5<sup>th</sup> January 2024

**Subject: Variation of Condition of planning permission SB/22/03137/FUL to allow for the substitution of previously approved plans under Condition 2.**

**Address: Paynes Boatyard, Thornham Lane, Southbourne, West Sussex, PO10 8DD**

DATE	DRAWN
Jan-24	DM
DRAWING No.	REV
21117 - 05	B

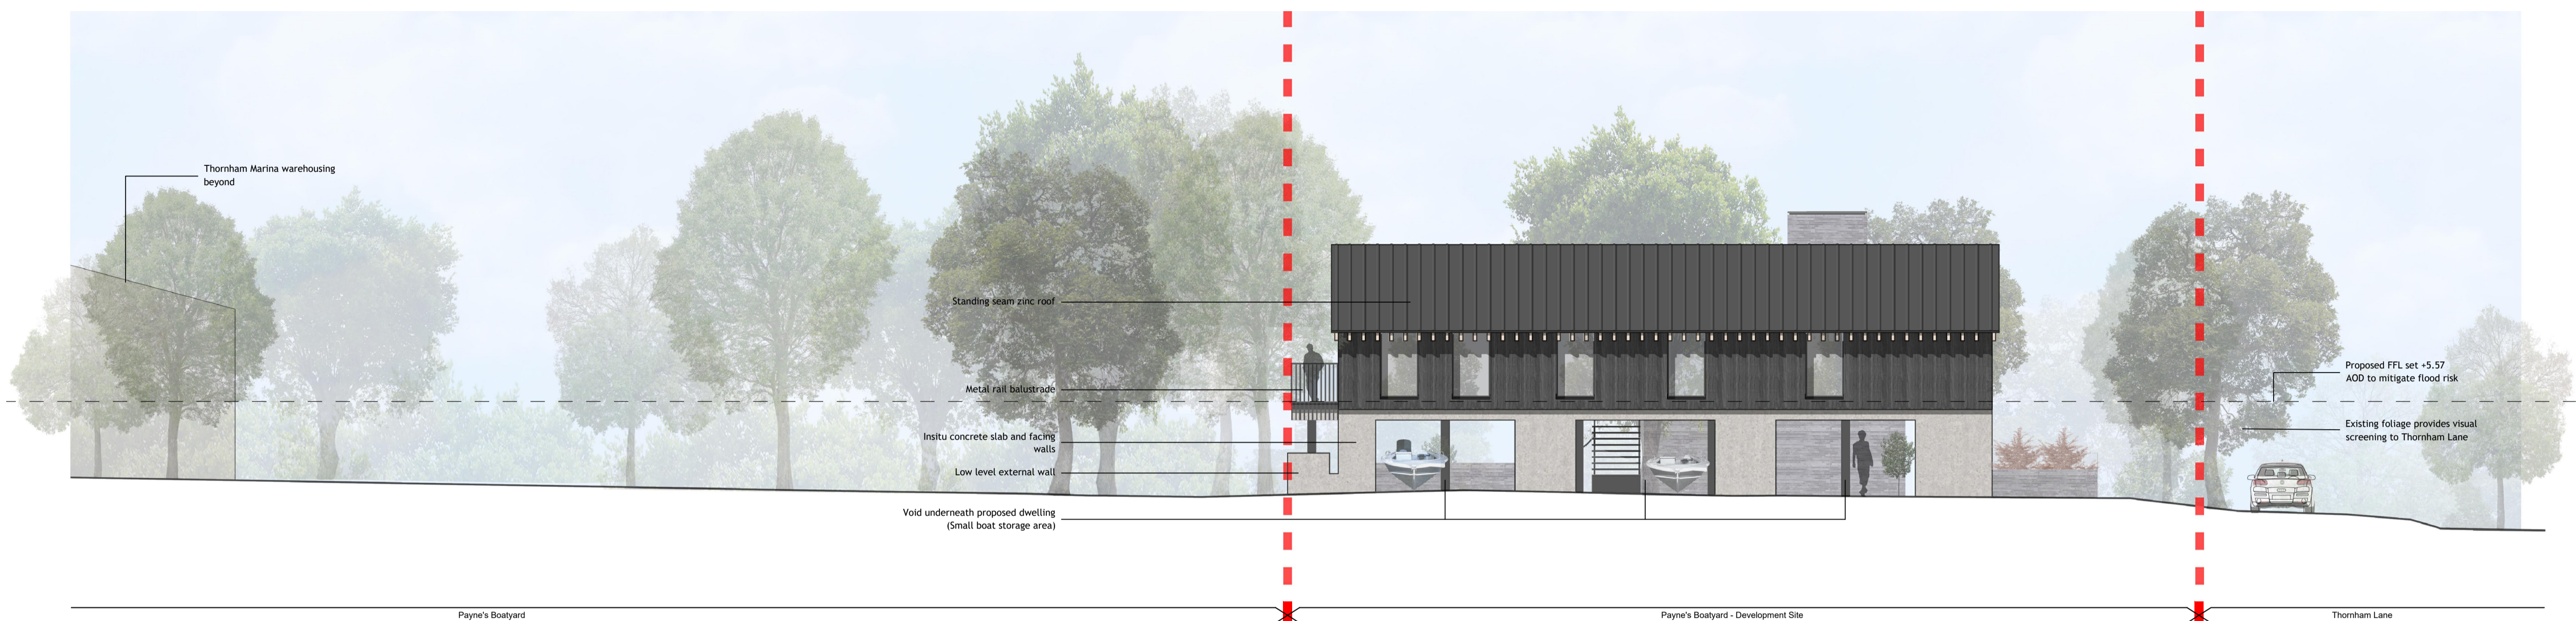
We are seeking to vary the condition to allow for the substitution of amended plans. The plan amendments do not seek to vary the scale or style of the design but instead amend the outlay of certain materials and reduce the extent of glazing. Grey masonry is proposed to replace flintwork and the concrete forming the exposed structural columns is to also be used for constructing ground level walls along the north-west elevation. The extent of timber cladding is to increase

across the habitable level of the north-west elevation. These changes enhance the robustness of the scheme given its marine location and do not impact the overall quality of the proposal.

The extent of glazing is to be rationalised with many elements being reduced in scale whilst some windows have been omitted completely. The roof light on the south-west elevation is now much smaller in size.
